Hole Farm Community Woodland, B186 Great Warley Street, Road Safety Audit Stage 1

Hole Farm Community Woodland, B186 Great Warley Street

Road Safety Audit – Stage 1

Document no: B2428401.LT.00-50 - Stage 1 RSA
Version: P03

Drawing Title
PROPOSED CAR PARK LOCATION PLAN

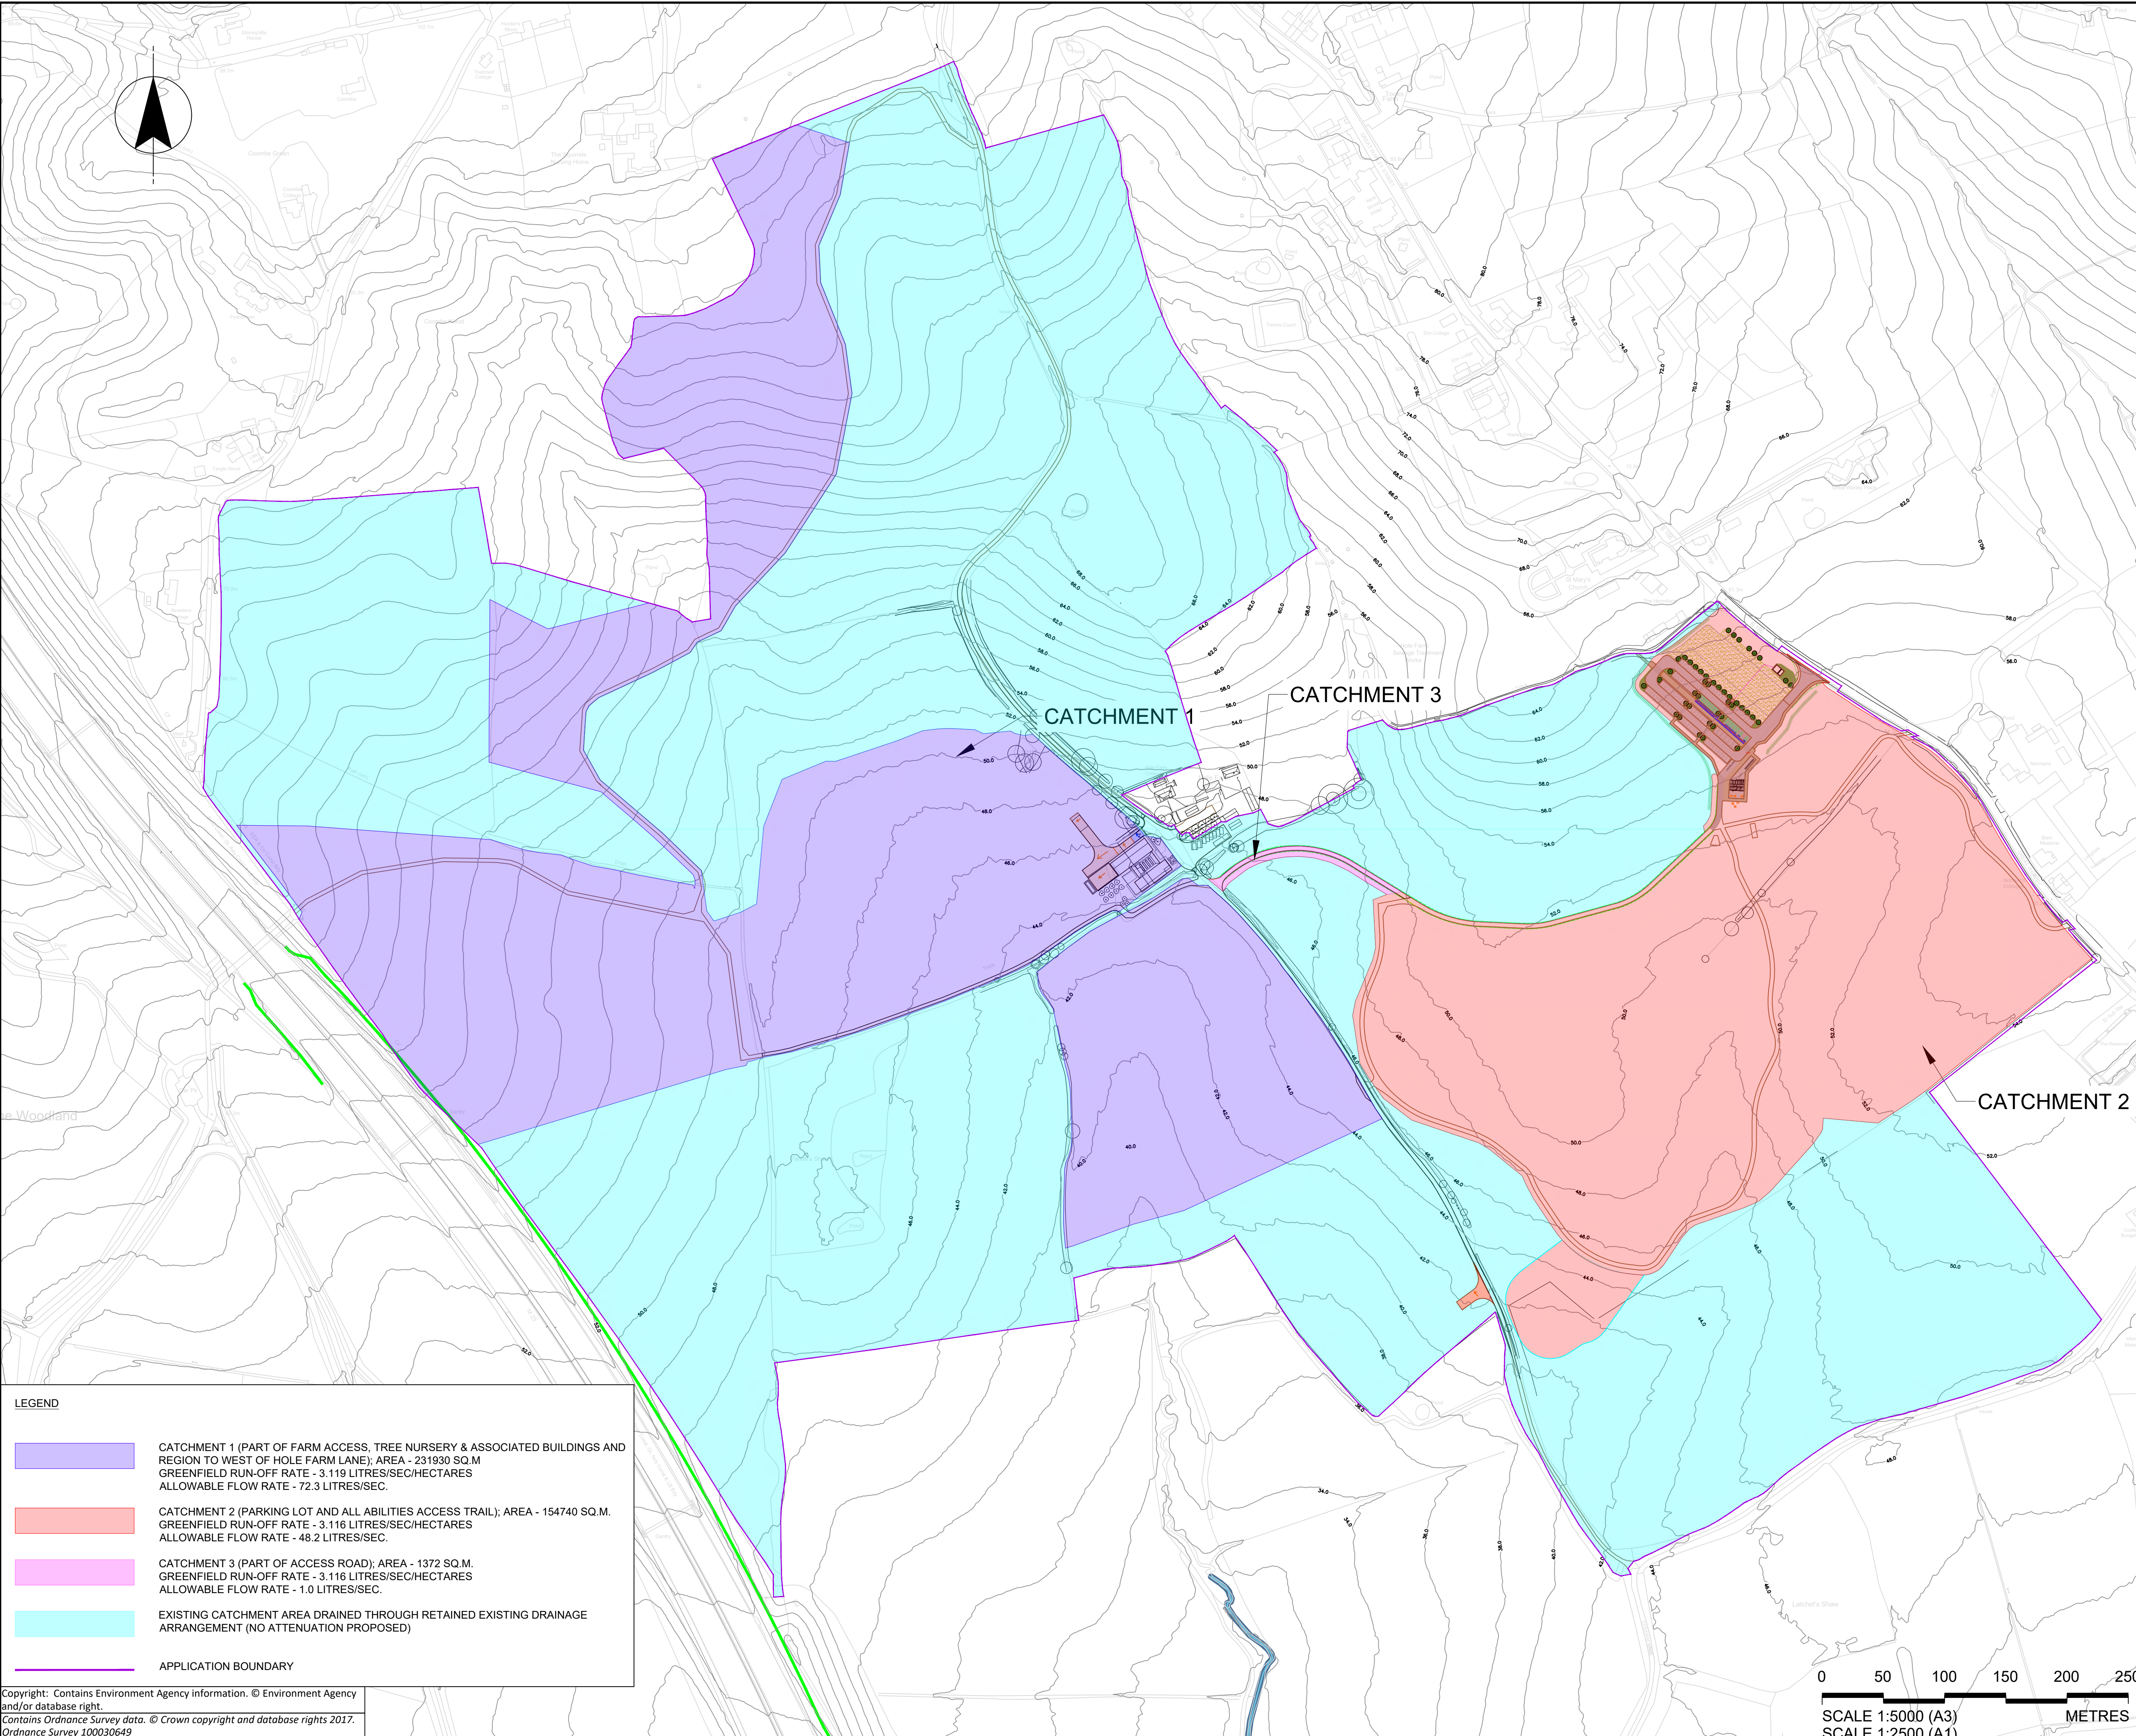
Summary: Lack of signing to advise large vehicles such as HGV's or Coaches that there is a height barrier at the entrance to the car park.

The Transport Statement (*Hole Farm Community Woodland: Transport Statement*) references that it is proposed to install a height and security barrier on the access into the car park. In addition, access off Great Warley Street into the car park is intended only for cars and a FTA Design LG Rigid Vehicle - 7m long only, also a 15m long, 4.157m high 6WS Luxury Coach. There is a risk that larger vehicles may not be aware of the height and barrier restrictions and turn off Great Warley Street to access the car park. This may lead to them having to reverse backwards to re-join Great Warley Street, leading to potential side swipe type collisions between motorists on Great Warley Street and the vehicle reversing, and injuries being sustained to the vehicle occupants.

Recommendation: Provide appropriate signing on Great Warley Street to the car park for all users, ensuring this access is signed for motor vehicles only.
